**KIRKLEES METROPOLITAN COUNCIL
INVESTMENT & REGENERATION SERVICE**

DELEGATED DECISION TO DETERMINE PLANNING APPLICATIONS

Reference No:	2023/62/92827/W
Site Address:	14, Bankfield Terrace, Outcote Bank, Huddersfield, HD1 3HW
Description:	Erection of single storey side extension and alterations
Recommending Officer:	Molly Storer

DECISION - REFUSED

Elevations - Proposed

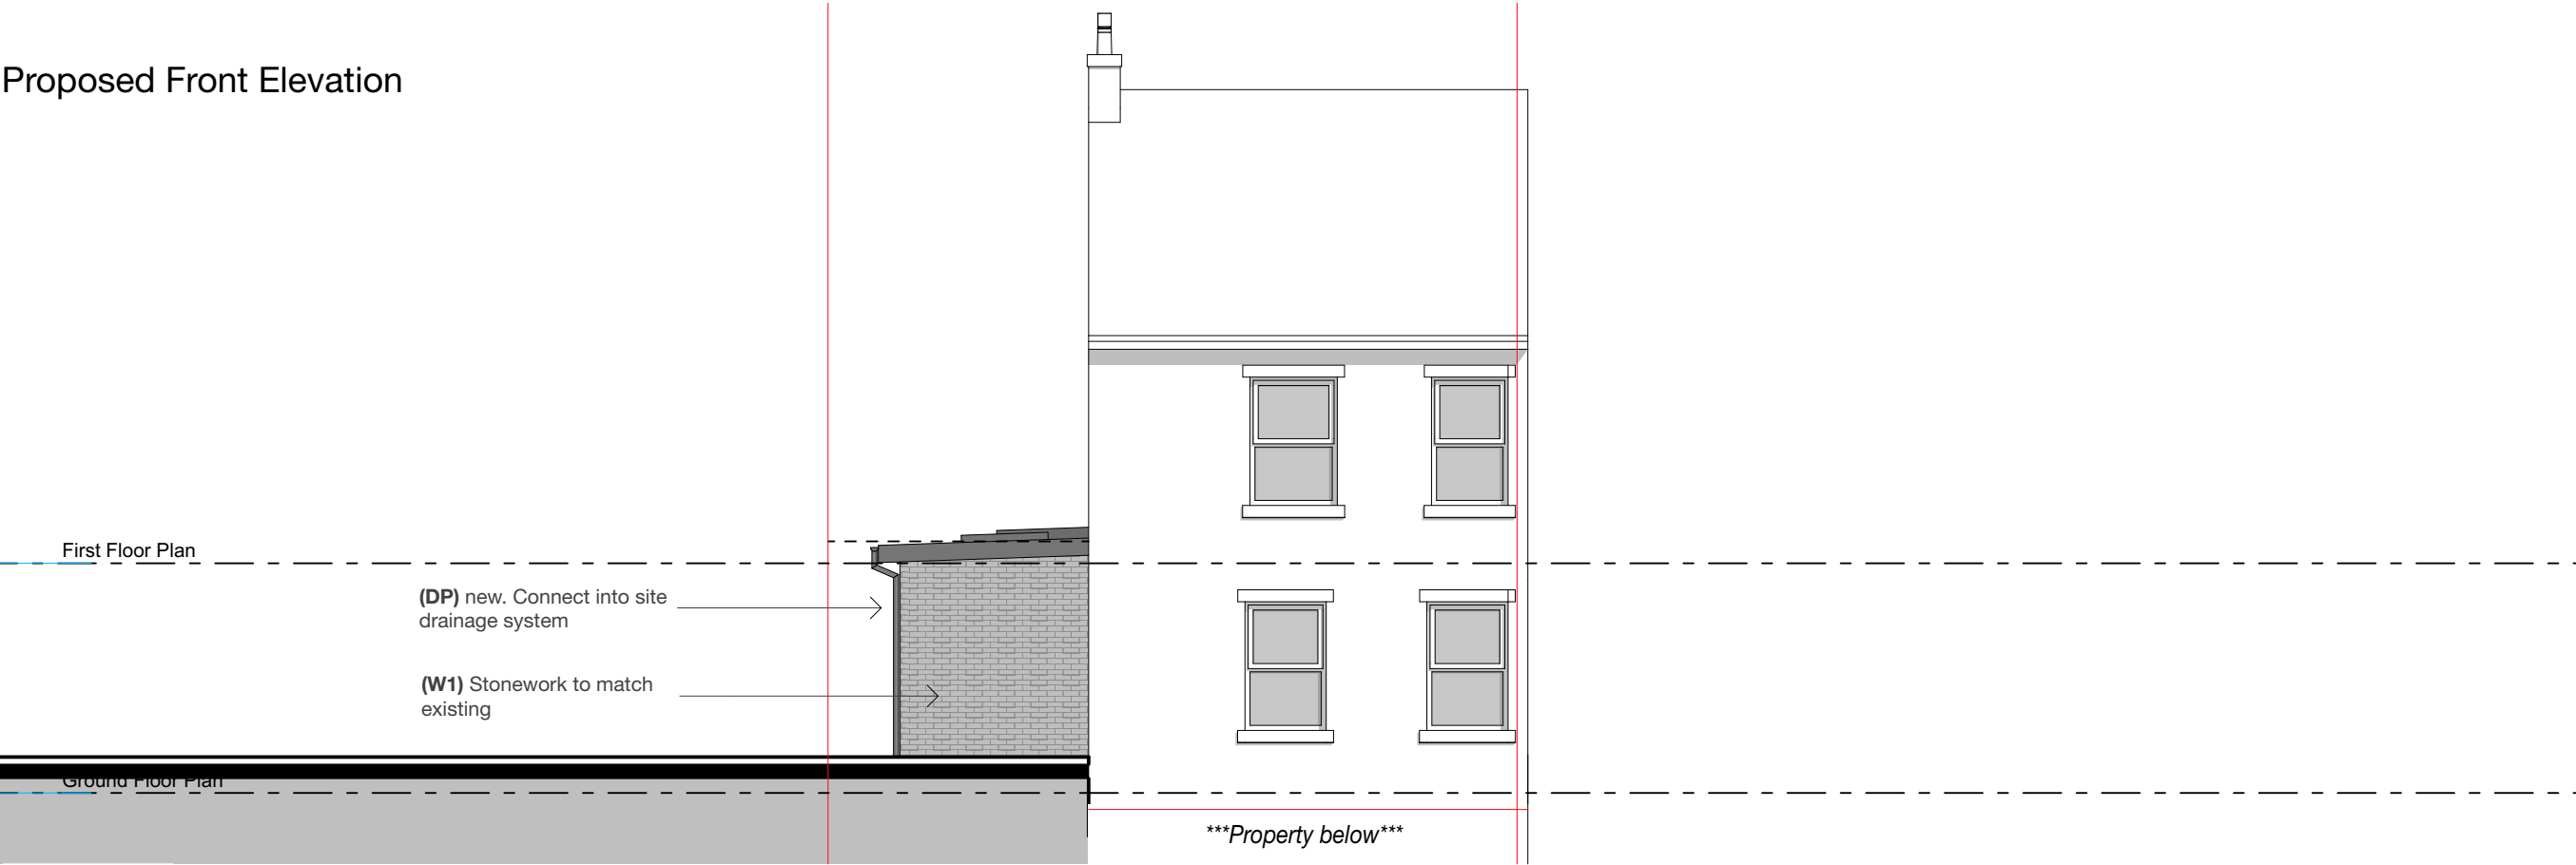
However the scale, design and appearance of the front extension is unacceptable and would cause considerable harm to the visual amenity of the host dwelling and wider area. It would overdominate the front of the dwelling, and no. 16. It is of an incongruous design and appearance with a 6-section bifold door and flat roof and would overlap the front elevation. It would be set up from the existing floor level of the host property which would further

promote its over dominance. In terms of the SPD section 5.2 on front extensions it is not well screened, not subservient to the original building and harms the character of the area.

The neighbouring house to the south occupies the same building line and same ground level as the host property. These properties occupy a relatively small area of land and are located in close proximity to one another, As such the proposed substantial massing extending significantly beyond the building line, set up from ground floor level of the dwelling would have an unduly overbearing, oppressive impact. Furthermore, the significant amount of glazing within the southern elevation facing onto this property at an elevated height further increases concerns in terms of privacy. Therefore, the bulk, massing and impacts upon privacy would result in such a close and overbearing impact that there would be a significant harmful impact on the amenities of the occupiers of the neighbouring property. The suggestion of privacy screening would not overcome the perception of loss of privacy.

1. The scale, design, siting and massing the front extension element of the proposal, would result in an incongruous and overly prominent form of development that would be out of keeping with the host dwelling and the small enclave of dwellings in which it would form part. It would cause harm to the visual amenity of the host dwelling and the character and appearance of the area. To permit the proposals would be contrary to Policy LP24 (a and c) of the Kirklees Local Plan, Key Design Principles 1 and 2 of the adopted House Extensions & Alterations SPD and paragraph 135 of the National Planning Policy Framework.

2. The proposed front extension element of the extension, by reason of its siting, scale and design would result in an unacceptable degree of harm in terms of the amenities of the occupiers of the adjacent 16 Bankfield Terrace with regards to loss of privacy an overbearing impact. To permit the proposals would be contrary to policy LP24 (b) of the Kirklees Local Plan, Key Design Principles 3 and 6 of the adopted House Extensions & Alterations SPD and paragraph 135 of the National Planning Policy Framework.

Plans - Proposed Ground Floor Plan

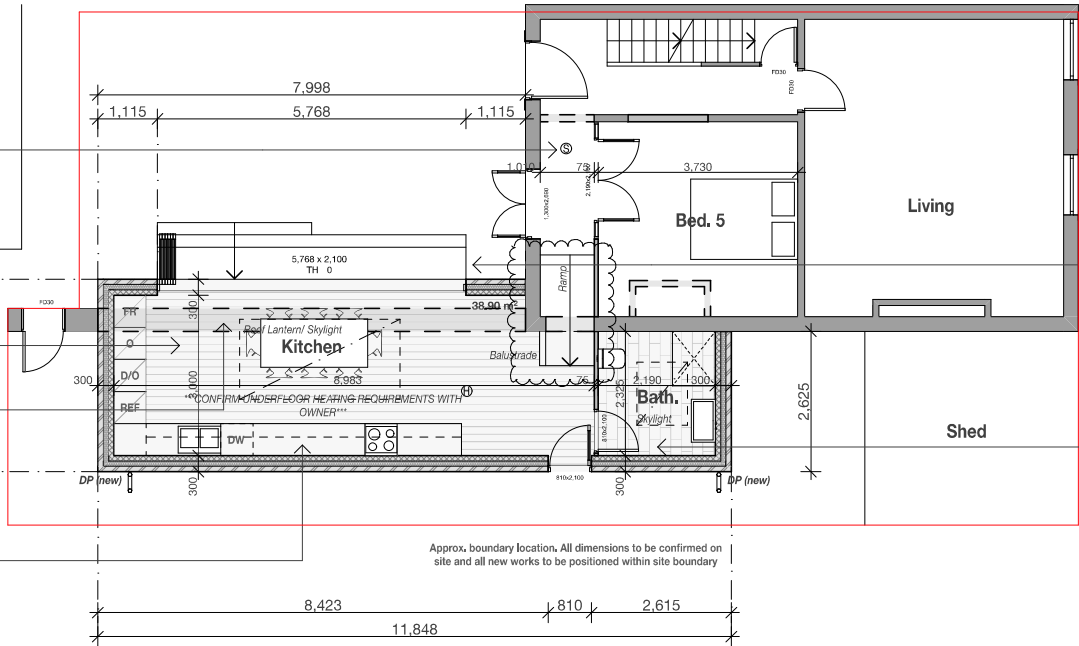
The agent was contacted as the front extension aspect of the scheme did not comply with the adopted SPD on house extensions and alterations. The agent was informed that if any amendments do not fully accord with the SPD, the document sets out that this would need 'full justification'. Specifically it was noted that when visiting the site it was observed that the significant projection, scale and fenestration in the extension would adversely impact on the adjacent residential property at no. 16 Outcote Bank (in addition to the impact on visual amenity). In addition, it was suggested that confirmation should be provided on the design of the extension, including the bathroom only being accessible by a considerable number of steps from the bedroom.

The agent responded by providing amended plans which compensated for a 'model error in the software' regarding the internal steps and explained that the extension's design prioritises ample space for wheelchair access, manoeuvring, and stationary resting. Additionally, the generously sized bathroom caters to the needs of occupiers. The agent stated that consideration was given to minimise visual bulk by introducing a low flat roof for the extension. It was stated by the agent that this would not significantly surpass the height of the existing retaining wall on the site and that privacy screening could be added if required to address concerns about overlooking at number 16.

The agent has set out that the proposed development has been designed to meet the specific needs of the applicant but, despite requests for further information, has not provided clear information as to how the extensions have been designed to achieve this. This includes why the kitchen extension is of the size and layout proposed or why a reduced scheme could not meet the expectations of the applicants.
